**RE: Gibson/University Cross Access Road
Gibson/University
Grading and Drainage Plan
Engineers Stamp Date 5/14/15 (M15D012D)**

Re: SEC Cross Access Driveway, 1600 Gibson Blvd. SE
Traffic Circulation Layout
Engineer's Plan Stamp Dated 5-14-15 (M15-D012D)

From: Wolfenbarger, Jeanne
Sent: Friday, April 17, 2015 11:24 AM
To: 'Jeff Wooten'; 'Kris Wiest'
Cc: Michel, Racquel M.
Subject: SEC Gibson/University Cross Access Driveway/Chick-fil-A - TCL Resubmittals ((M15-D012C and M15-D012D)

Re: SEC Cross Access Driveway, 1600 Gibson Blvd. SE
Traffic Circulation Layout
Engineer's Plan Stamp Dated 3-17-15 (M15-D012D)

#### Pavement Sections

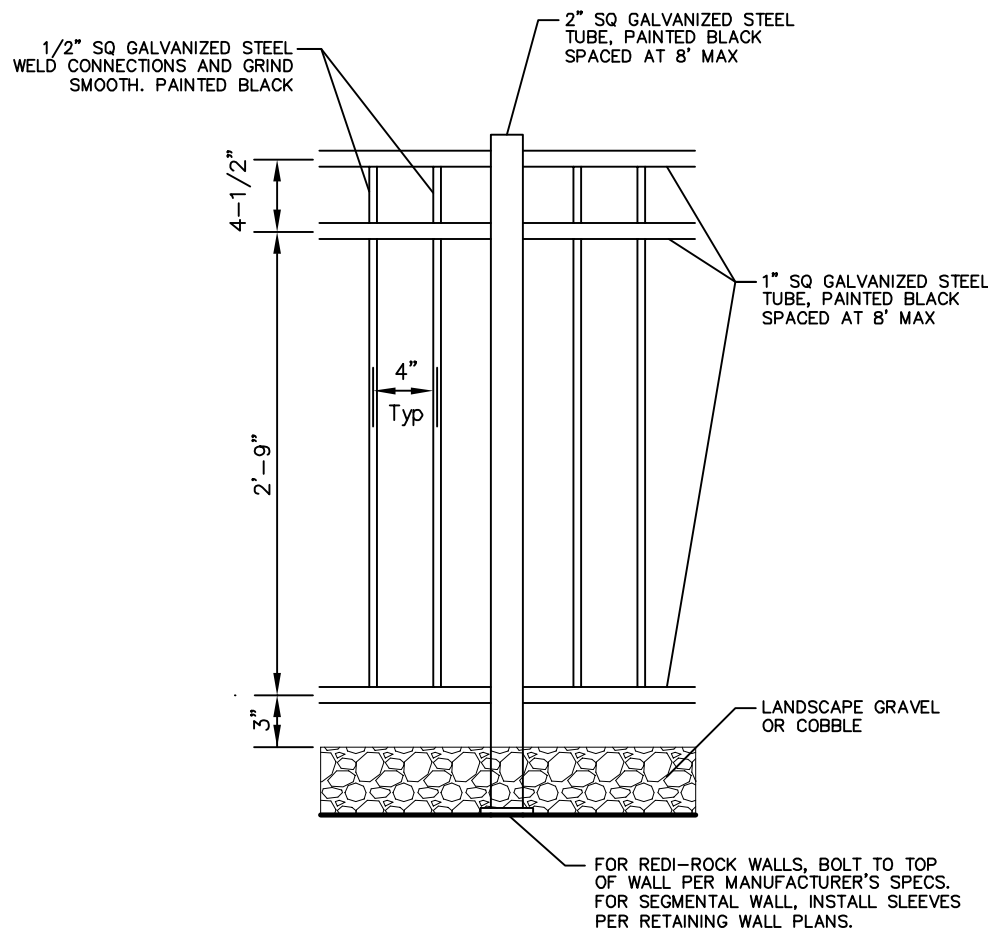
- The pavement section that you show is not an exact match for what is shown on the Merrick planset. (Your plan set calls for 12" subgrade, while the other plan set doesn't. The Merrick set calls out for a 1.5" lift and a 2.5" lift while your detail on Sheet C7 does not contain actual details of lift thicknesses.) This does not affect TCL approval as much as I just wanted to point this out to make sure there is not any confusion during construction with regard to exactly what pavement section to build for your access. If there are different pavement sections being used from one planset to the other, this ought to be reflected on each of the different plan sets.

Project Number 2014055
Drawn By JW
Checked JW
Issue Date March 17, 2015
Overall Site Plan

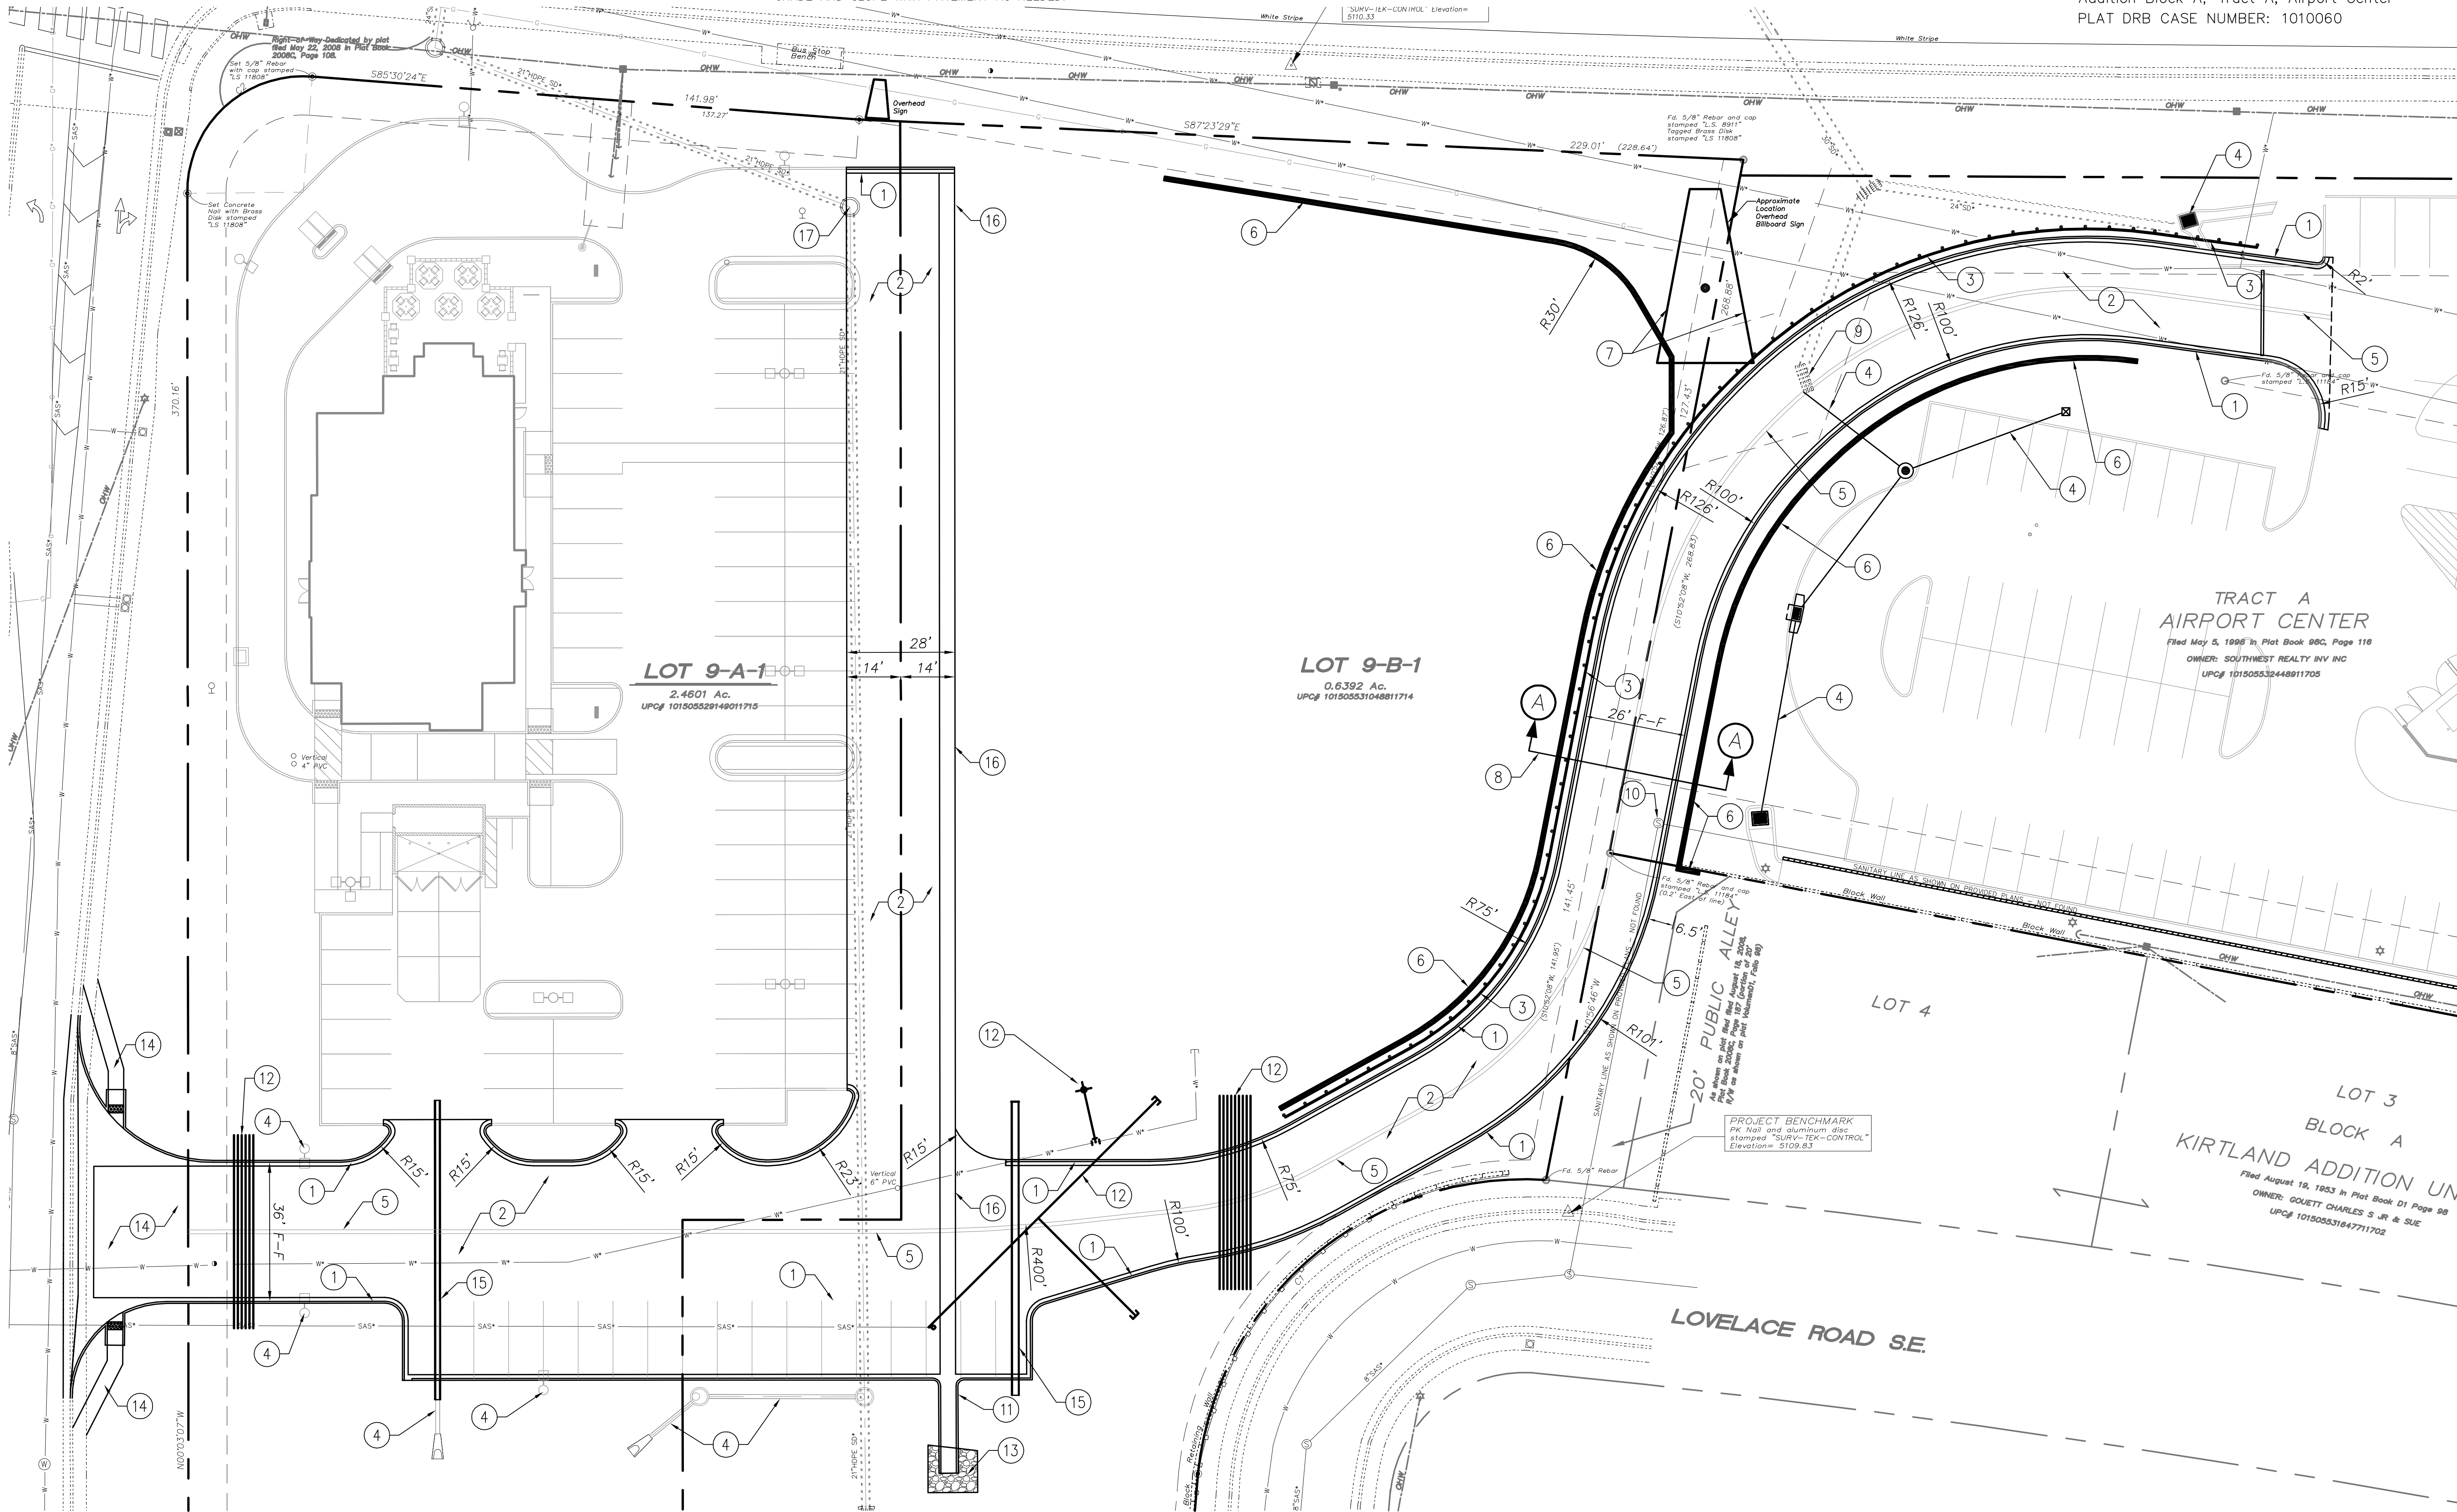
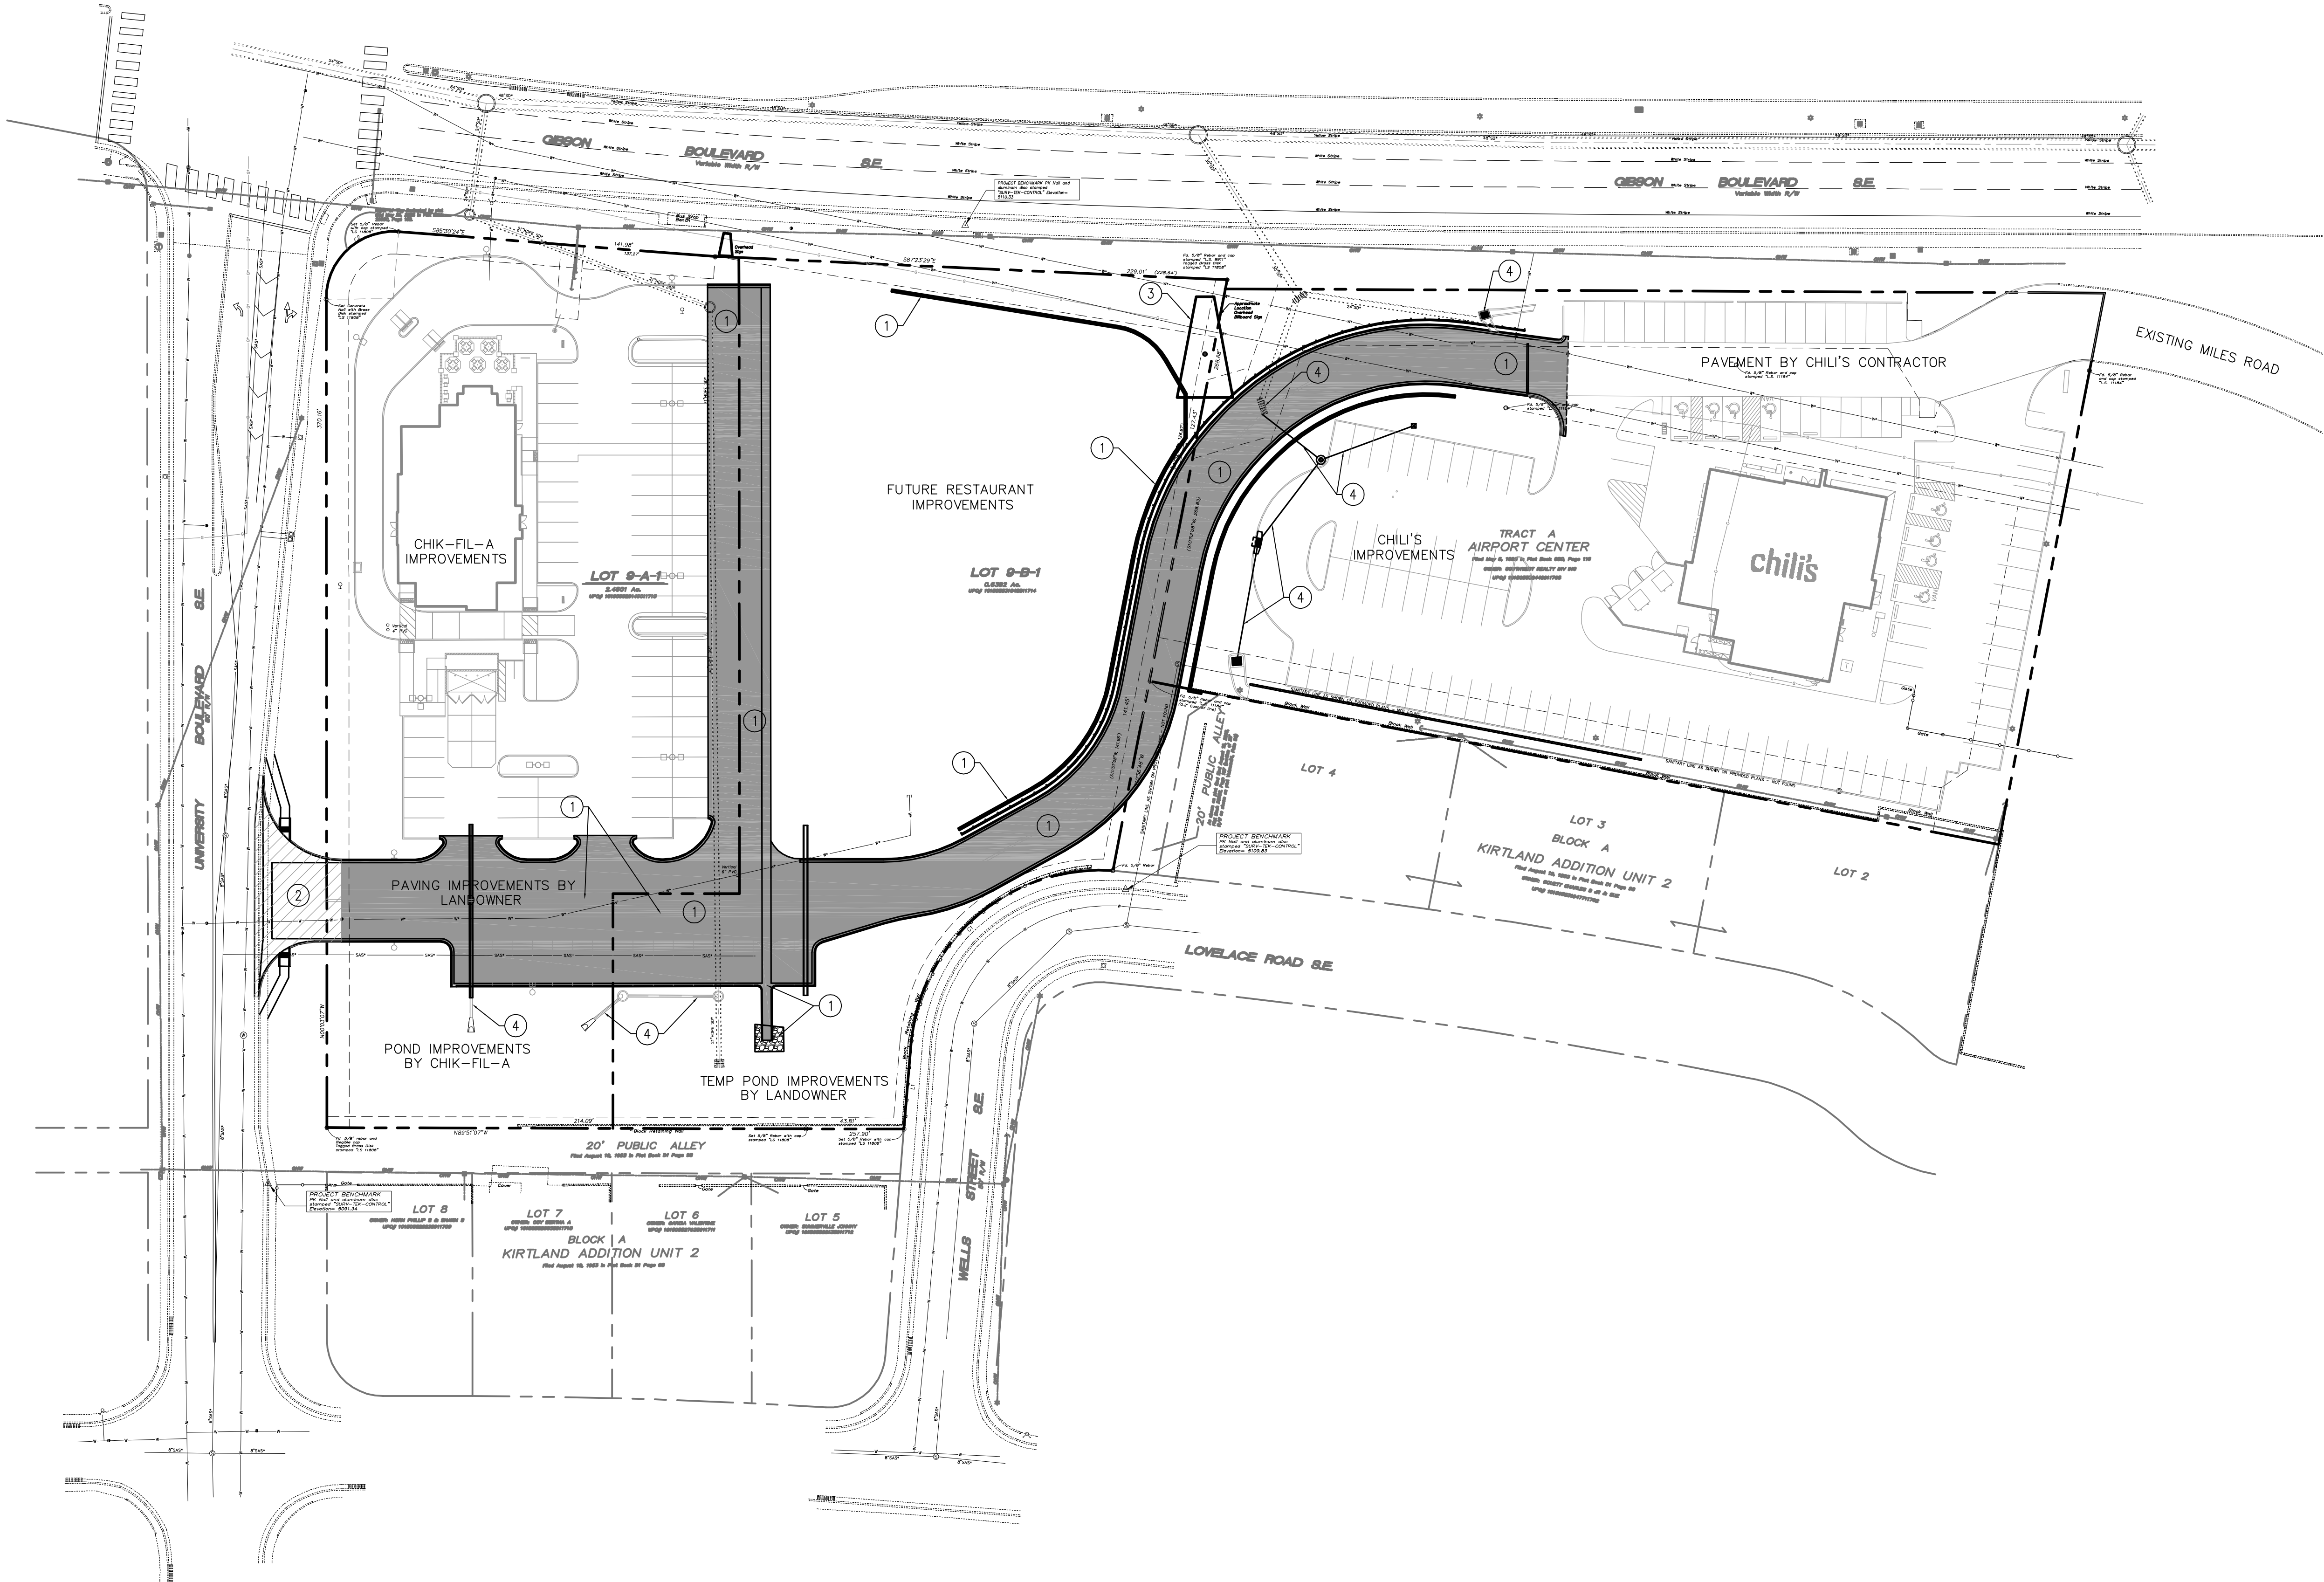
Kris and Jeff, for the most part the TCLs look good with very minor comments this time. As you know, the TCLs cannot be approved until the access agreement is signed at DRB and the TIS is approved, and any changes that are recommended as part of the TIS are shown on the site plan. (I called Terry Brown, and he is supposed to get me the first draft copy of the TIS next week for review.)
